SUBMISSION 2: SUMMARY OF ADDITIONAL CONCERNS IN RELATION TO THE PROPOSED NORTHCONNEX TUNNEL

Application number - SSI 13_6136

This is an objection to many aspects of the proposed NorthConnex tunnel.

MOTORWAY OPERATIONS COMPLEX - SOUTHERN VENTILATION FACILITY - SECTIONS
M1-M2-5000-DR-JD-0525

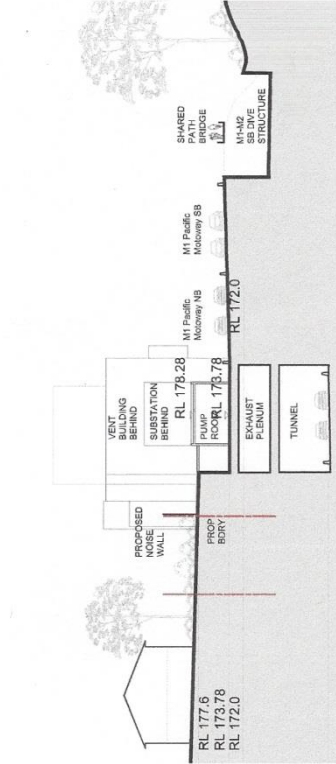
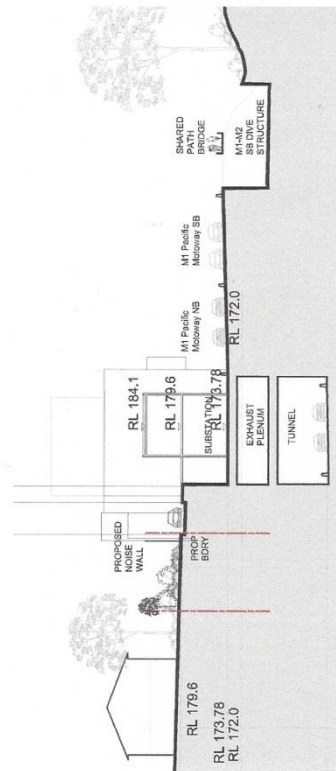
Speakers at the NorthConnex Air Quality Forum spoke of the importance of the topography in the placement of the ventilation facilities. In the NorthConnex proposal the southern ventilation facility is at the lowest point of the M2 intersection where it is surrounded on three sides by hillside cuttings. In this location the “discharge point” will barely be above the adjacent high ground.

How can this be the most suitable position for the outlet when land that is more suitable is already owned and available?

Much is made of the intention to discharge the polluted air through the stack at 13 – 19m/s. Given that the stack is only 15m above Pennant Hills Road, a simple calculation indicates that the particles will be ejected to a height of between 23m and 33m above Pennant Hills Road. That will only be sufficient for them to be dispersed by prevailing winds IF there is wind and it is strong enough. For instance, the weather history graph showing the wind speed and direction at West Pennant Hills measured on the 24th August 2014 indicated that there was no wind until 9am and what wind there was, came from the west. Wind speeds of less than 2m/sec (ie about 8km/hour) are not considered sufficient to disperse pollution from the stack. Only a very few gusts on this day were in excess of 8km/hour.

That the Government ensures that the southbound ventilation facility ie the Stack, be located at the south-west corner, on the RMS owned land, at the edge of the Pennant Hills Golf course. In this location, the southbound tunnel can be efficiently, effectively and economically ventilated.

The impact of the stack plumes on the surrounding residential areas must be modelled using its current proposed position and height and also modelled with the stack positioned on the golf course side of Pennant Hills Road, where it is topographically higher. This would allow an objective, impartial, scientifically based assessment to be made of the most effective location for the stack.
